Change of use of land for the stationing of 14 No. mobile homes for permanent residential occupation. This application is a Departure from the Development Plan.

Land to East of Torri House Old Mead Road Littlehampton

Thank you for your internet representation made on 22nd January 2018 which has been recorded as '**no objection**' with the comments as follows:

Site Plan	
Date	November 2017
Scale	1 : 500 @ A3
Sheet	MJS/11-2017/ PL47-02

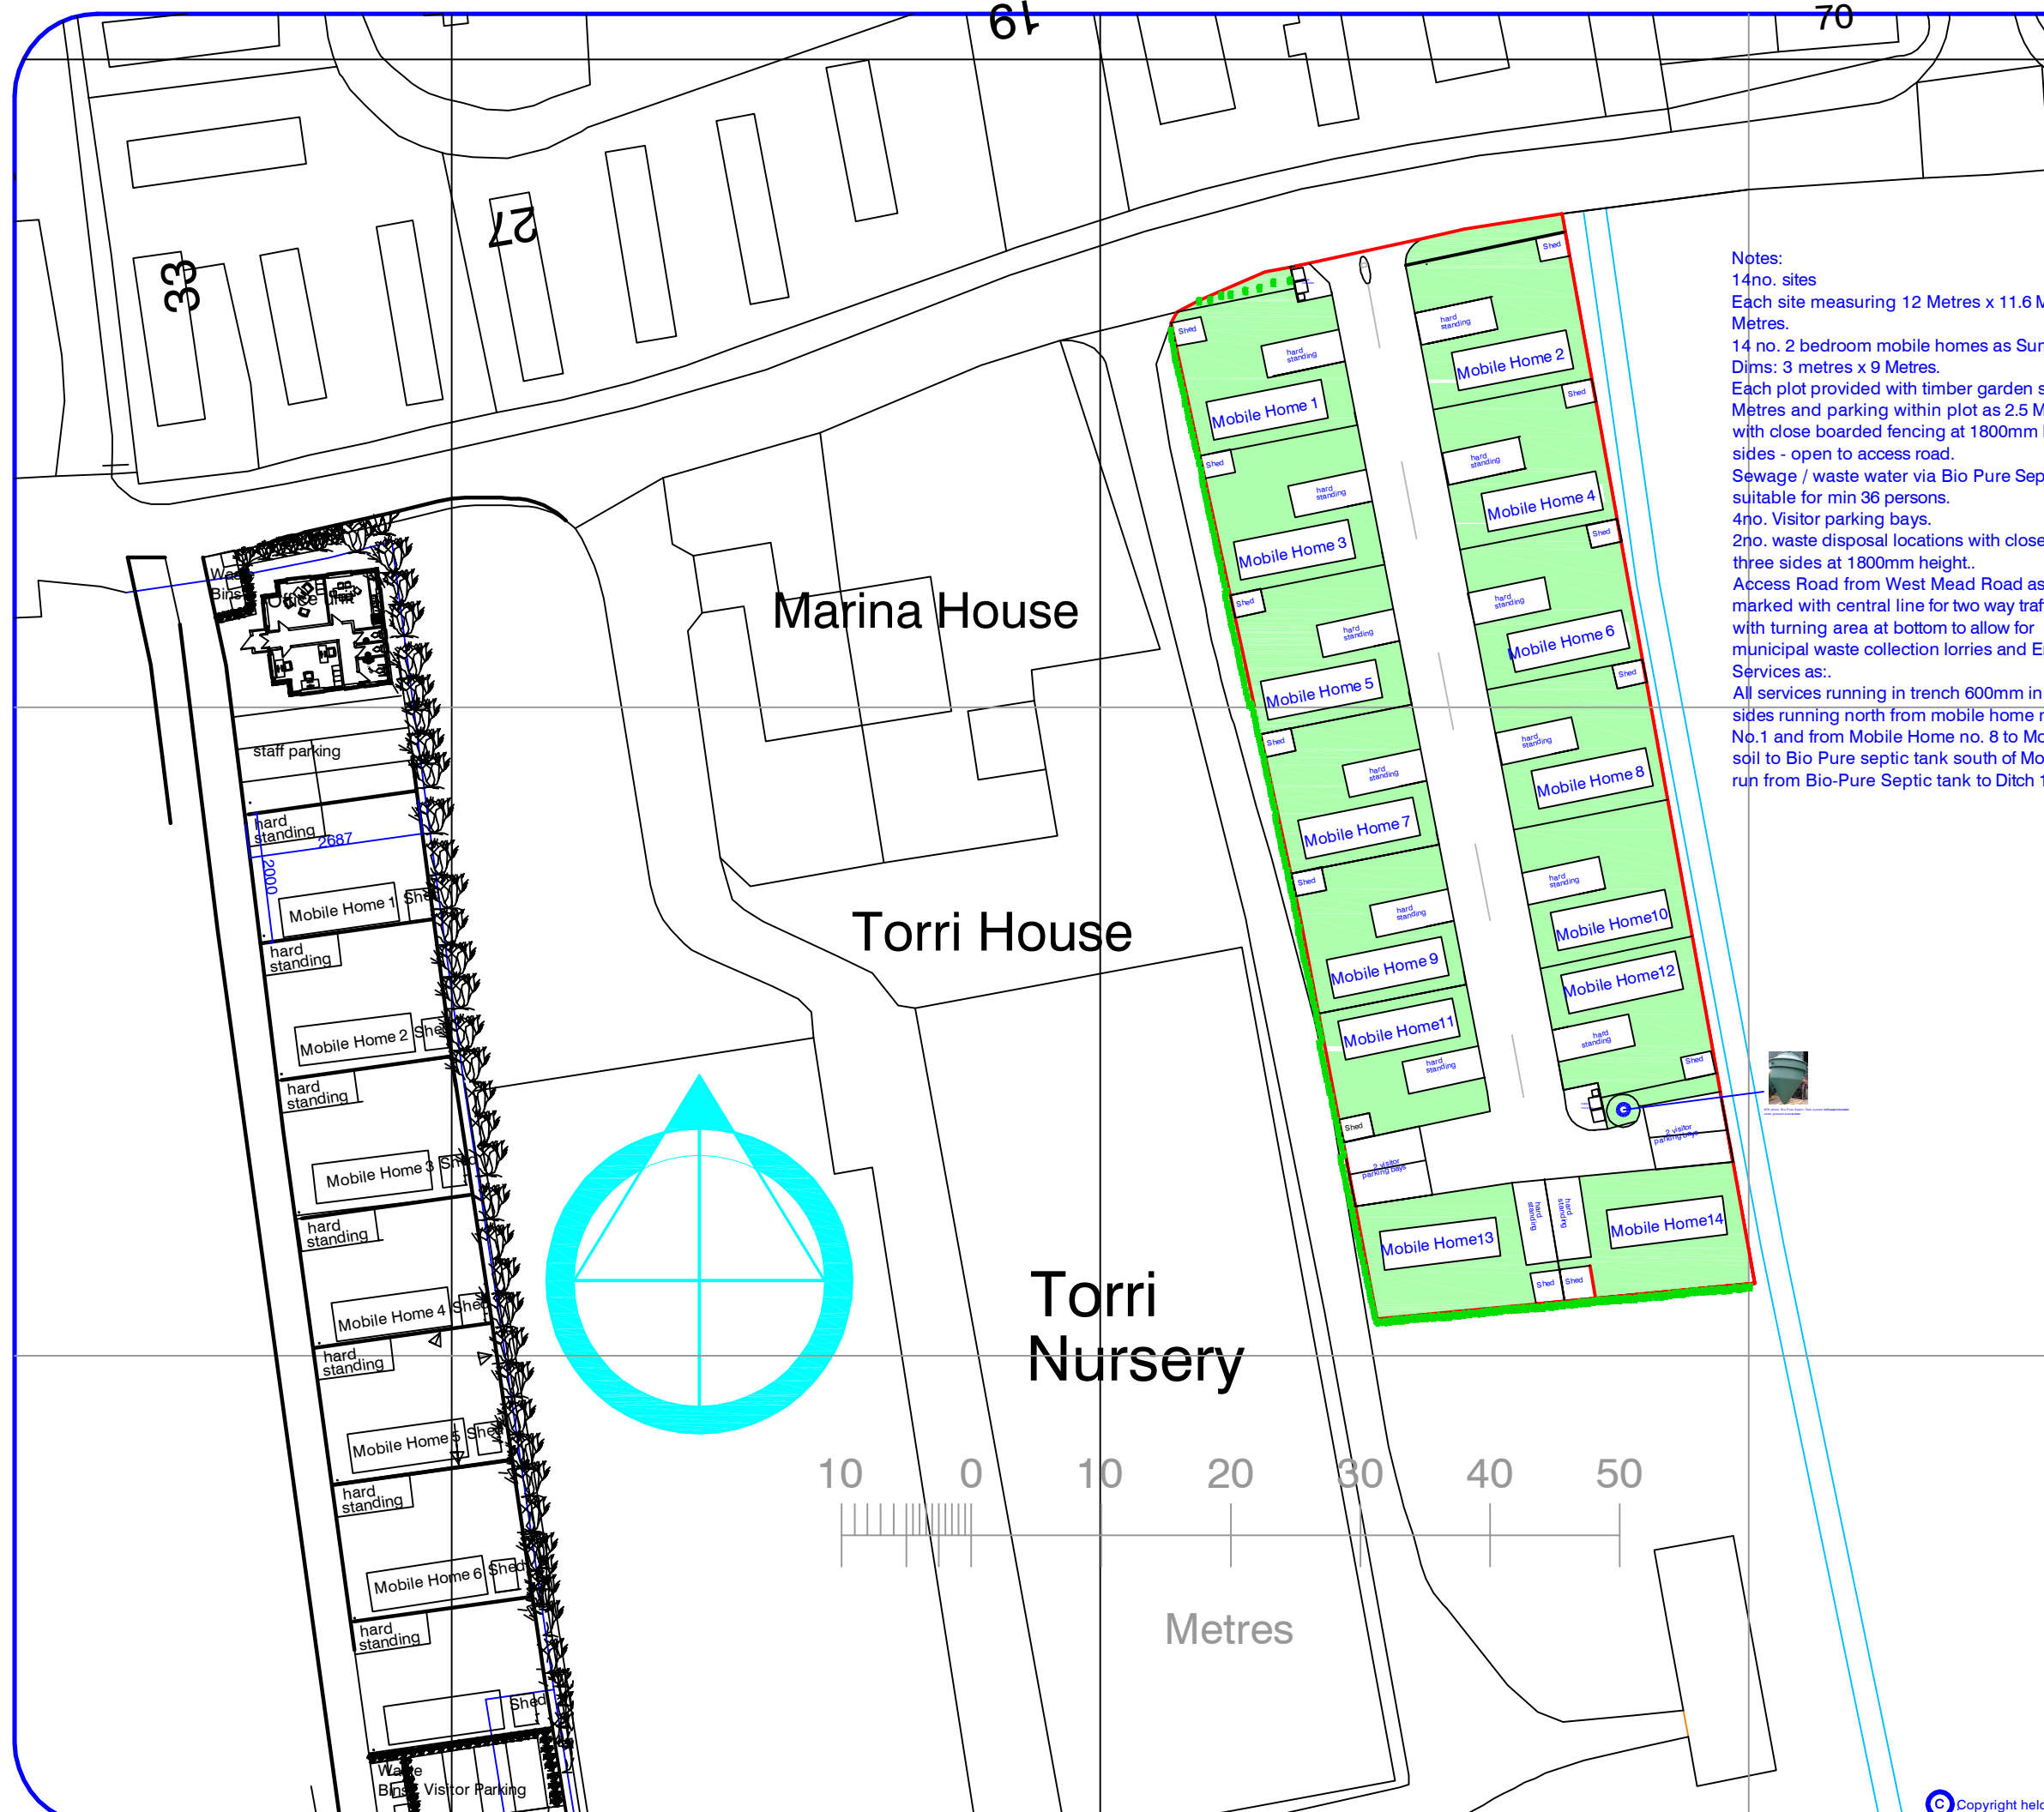
Under the building regulations of January 2015 it states that if the development is within 30 metres per unit of a main sewer the development must connected to the main sewer. Mr Molica is intending to develop 14 Unit's, therefore this development is within 420 metres (30 x 14) of the main sewer they must be connected to the main sewer not a septic tank as per application. There is also the question of how and where the surface water is to be drained to as nothing is indicated on the planning. The entrance to this site is on a slight curve in Old Mead Road where visibility is not clear until you are actually driving past that curve therefore there needs to be clear visibility splayed designed into the plan layout. This is not showing in the current plan.
